CITY OF ALBUQUERQUE

Re: 2633 Floral Rd. NW
Request Permanent C.O. – Approved
Engineer's Stamp Date: 10-12-2020
Certification dated: 4-16-2021

Based upon the information provided in your submittal received 4-19-2021 and site visit on 4-22-2021, this plan is approved for Certificate of Occupancy by Hydrology.

**2633 FLORAL ROAD, NW
GRADING PLAN**

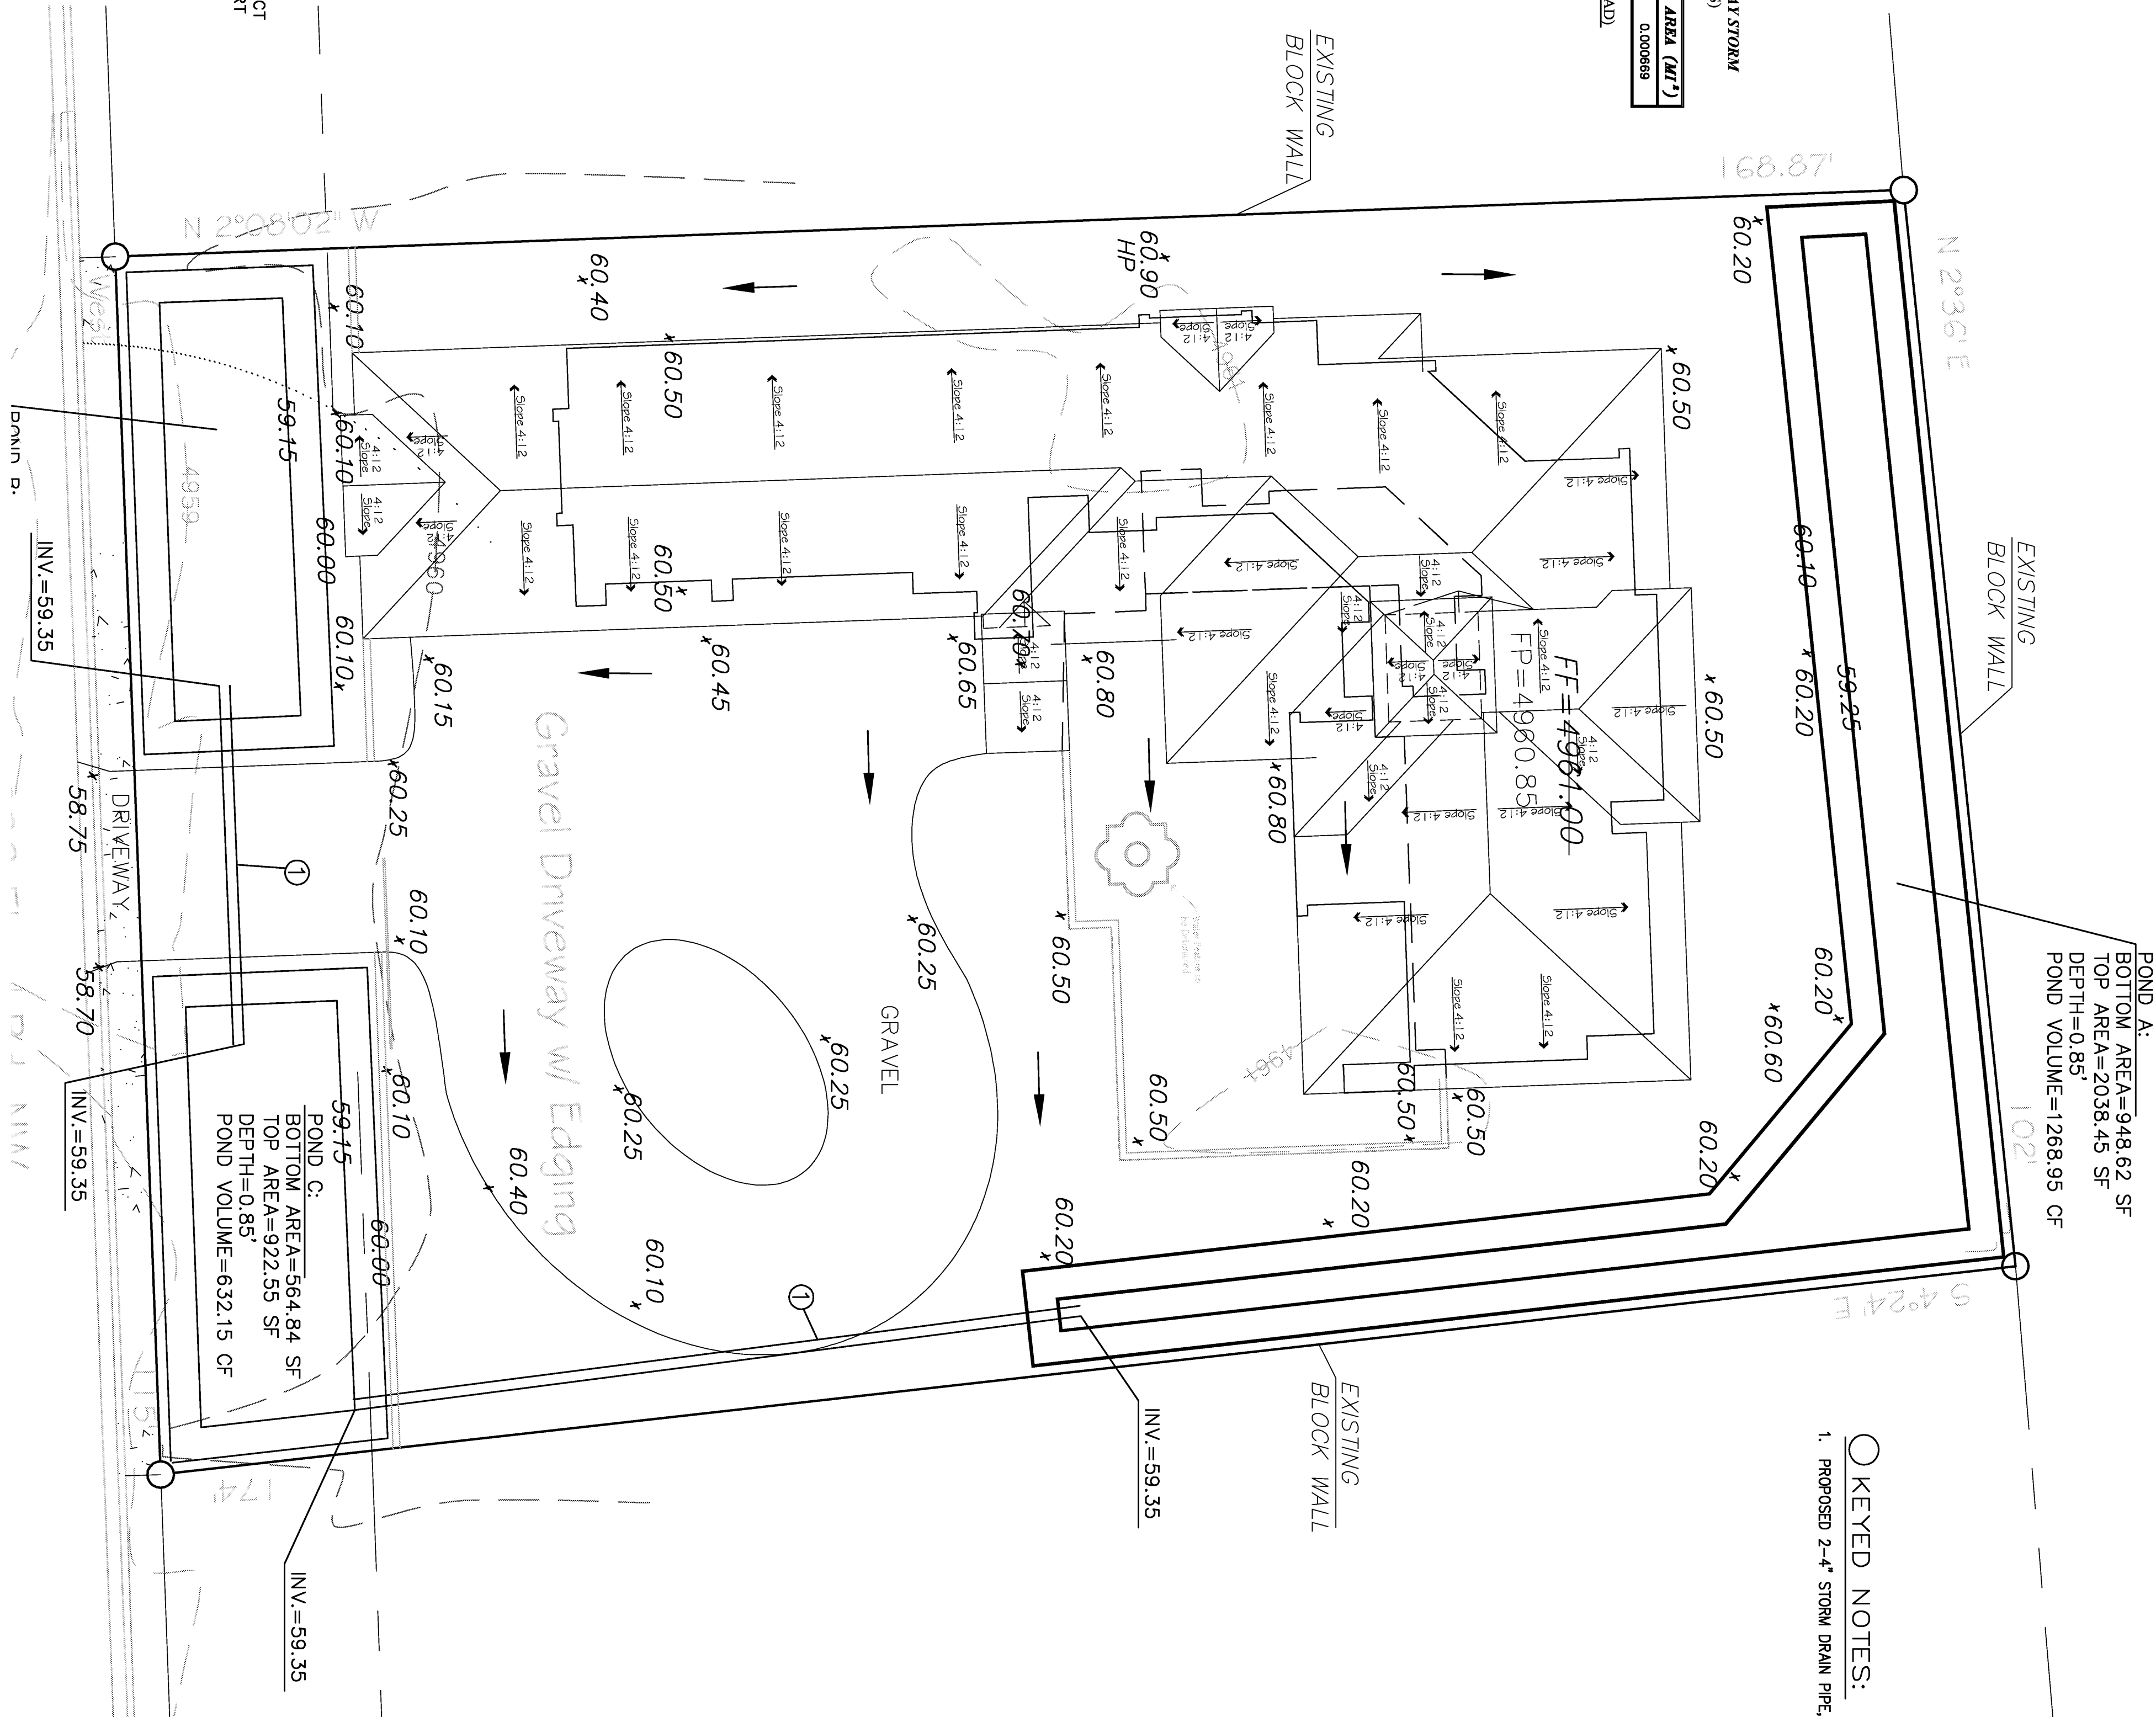
Please note that there is still work that needs to be completed onsite. There is a large pile of dirt in the front of the lot that needs to be taken care of, the grades around the ponds need to be cleaned up and the pipe connecting the pond in the back yard to the pond in the SE corner appears to be misaligned. The inlet is on the upside of the slope near the wall and needs to be placed in the bottom of the swale as shown on the plans. Please have the contractor take care of this.
